Sent: 25 September 2026 13:13
To: DC Admin
Subject: Planning Objection 2025/62/93355/E Land Off Woodward Court

RE: Planning Application Objection 2025/62/93355/E Land Off Woodward Court

TITLE	HEPWORTH LANE / FLASH LANE / SHILLBANK LANE EXISTING HIGHWAY LAYOUT
REF	FIGURE 11
SCALE	1:200 @ A3

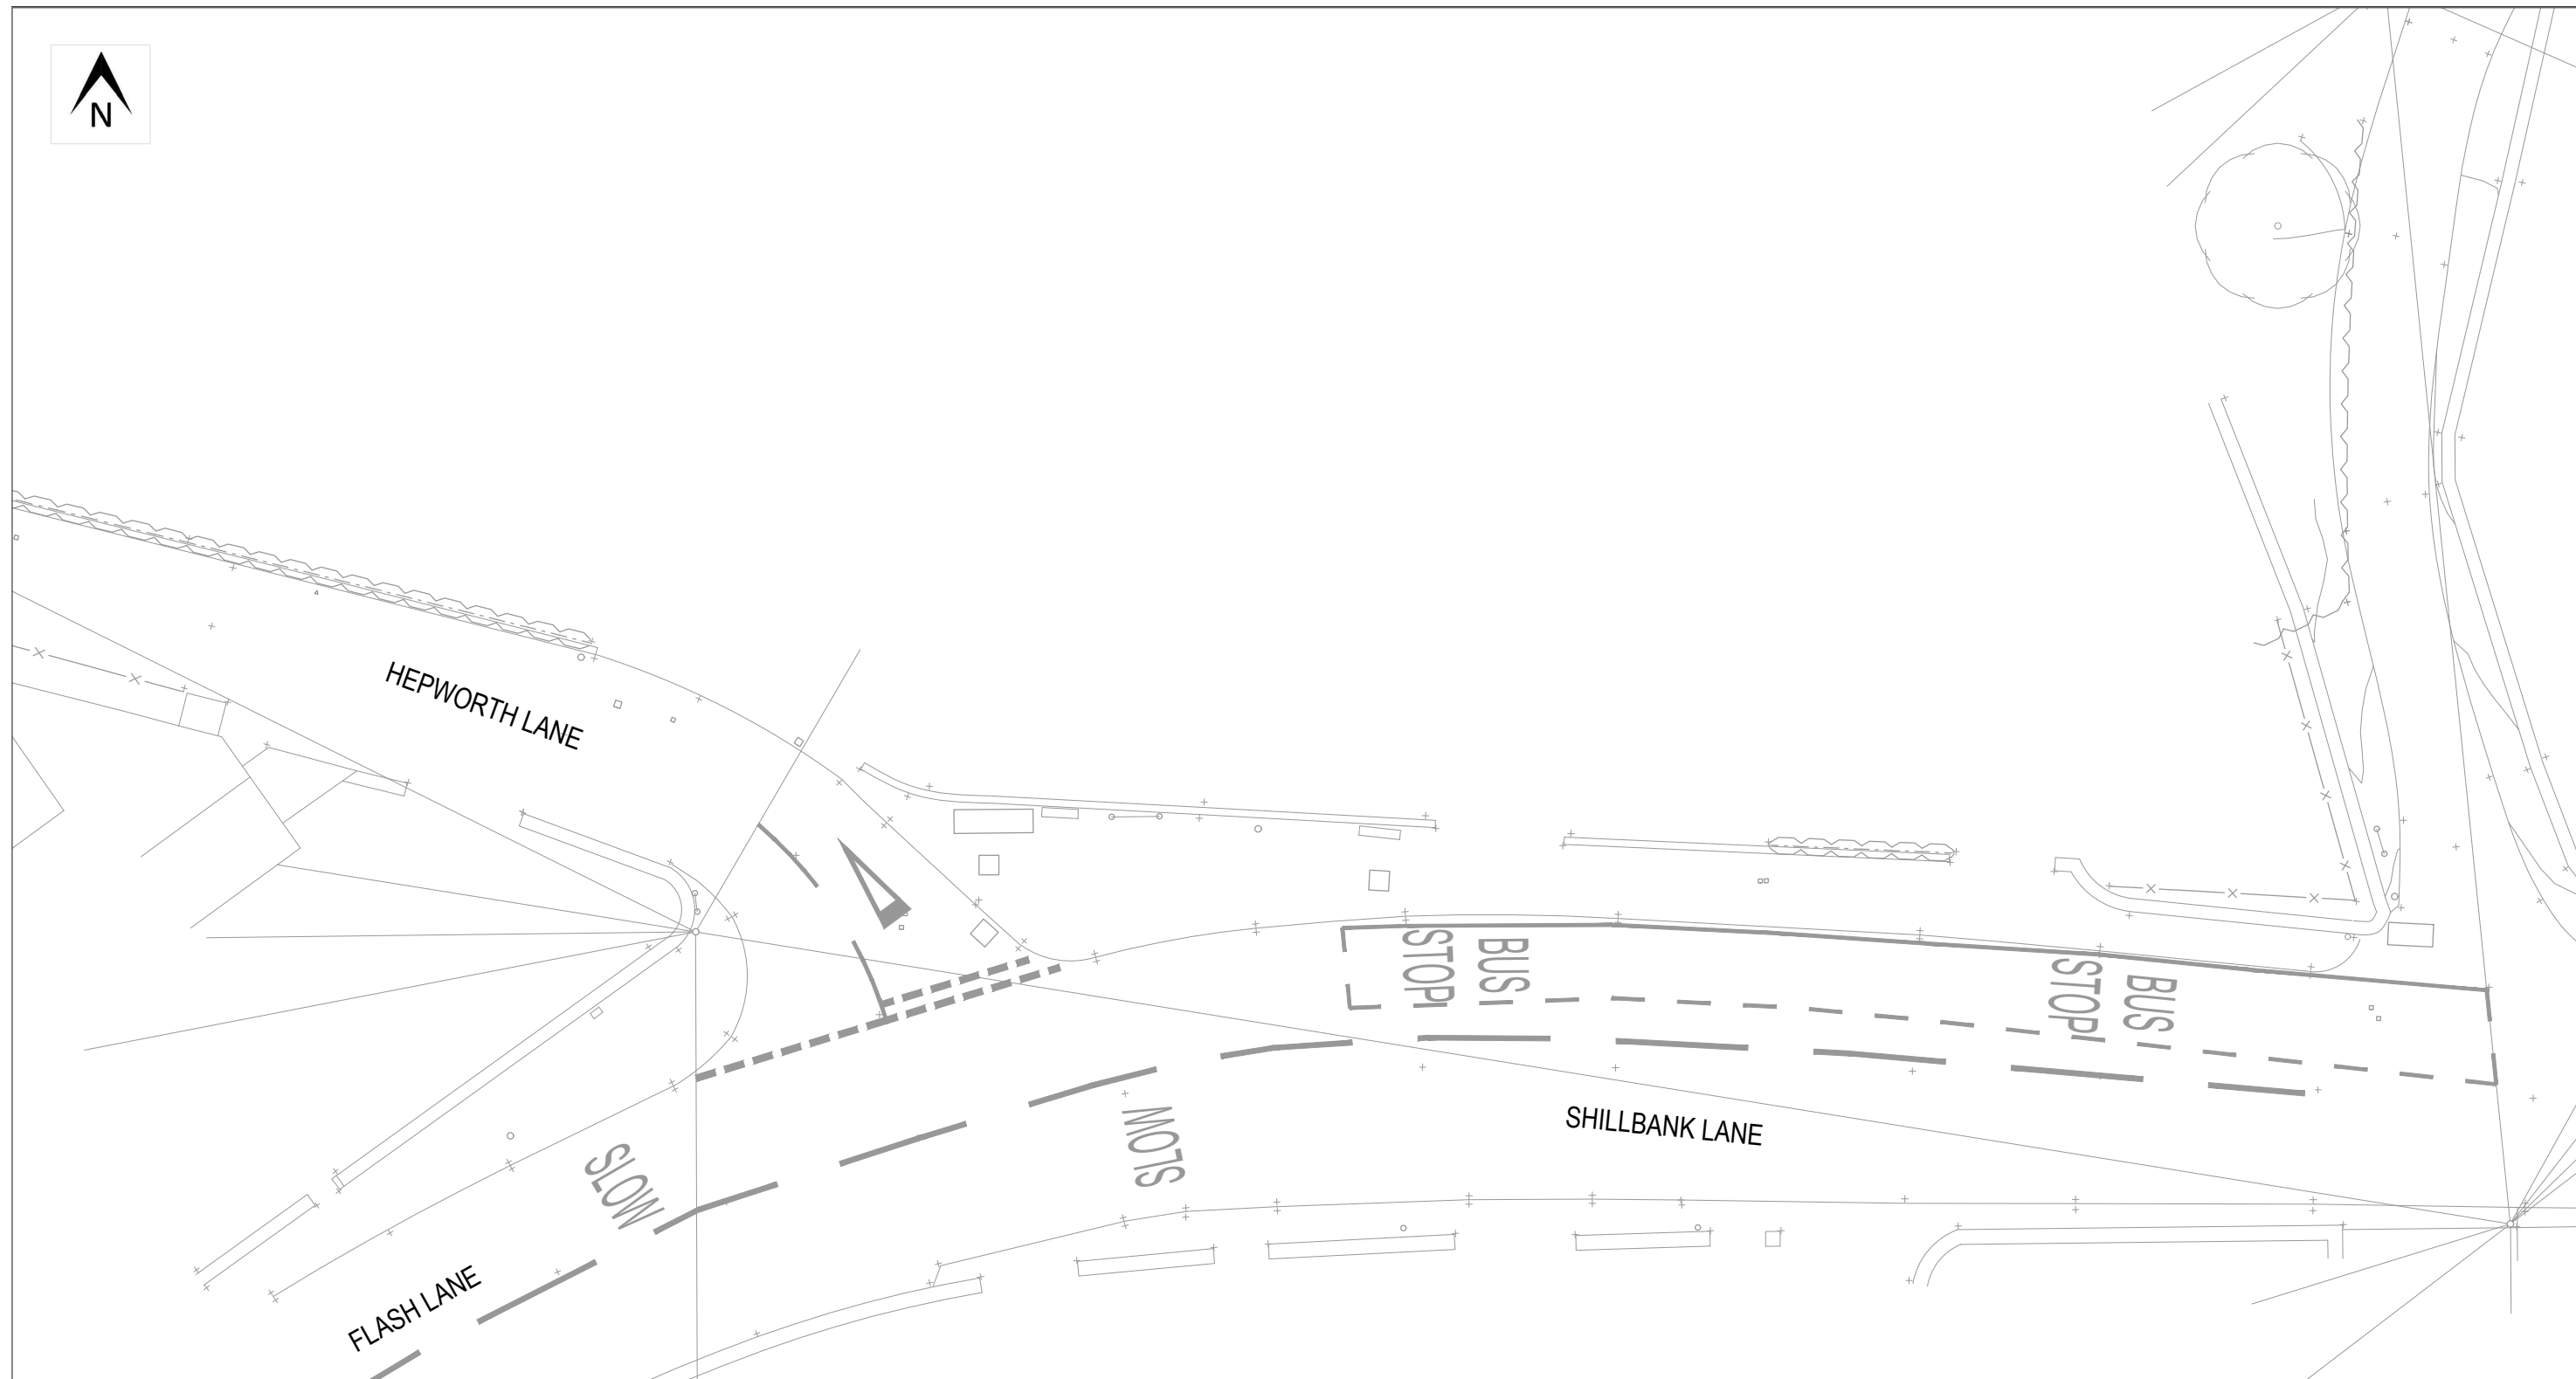
- **Narrow Pinch-Points and Lack of Passing Provision:** As shown in **Photo 2** (view entering Hepworth Lane from Flash Lane), the carriageway is exceptionally narrow and only wide enough for single-file traffic, with no passing places available past Hepworth Drive. Drivers turning out of the proposed access cannot see oncoming vehicles, creating an immediate highway conflict point with nowhere for vehicles to safely yield or pass. The proposed exit is not even visible so there is no way of knowing if vehicles are exiting the proposed exit and if they are you are going to meet them head on.

Image 2.3 Proposed Hepworth Lane Site Egress

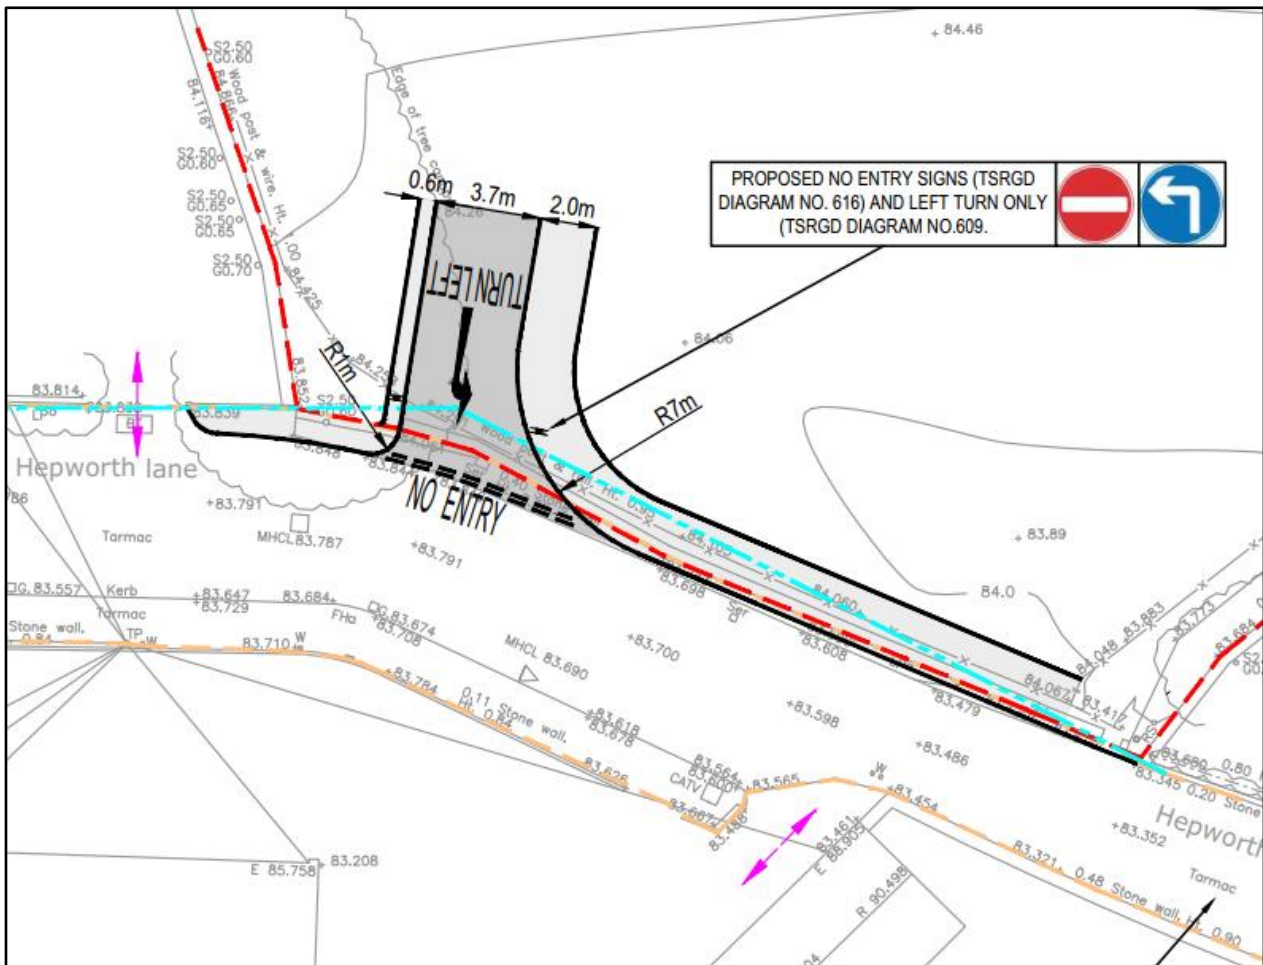
I would like to reiterate my serious concerns regarding the proposed site exit onto Hepworth Lane, specifically regarding safety for residents exiting Hepworth Close. Having reviewed the applicant's Traffic Survey, I believe it fails to adequately evaluate the severe sightline restrictions and safety risks at the junction of Hepworth Close and Hepworth Lane.

- **Severe Sightline Restrictions:** As shown in **Photo 1** (view from my vehicle exiting Hepworth Close onto Hepworth Lane), visibility of the proposed exit is completely obscured. Vehicles turning right out of the proposed exit create a direct head-on collision risk with vehicles exiting Hepworth Close. Furthermore, there is no visibility of vehicles entering Hepworth Lane this has resulting in several near misses

- **Cumulative Impact:** Adding approximately 150 additional vehicle movements—combined with existing peak school run traffic using Hepworth Lane as a cut-through—poses an **unacceptable impact on highway safety**.

- **Planning Policy Reference:** Under **Paragraph 115 of the National Planning Policy Framework (NPPF)**, development should be prevented or refused on highways grounds where there would be an *unacceptable impact on highway safety*. The proposed access also fails to comply with visibility splay and safe design standards set out in **Manual for Streets (MfS)**.
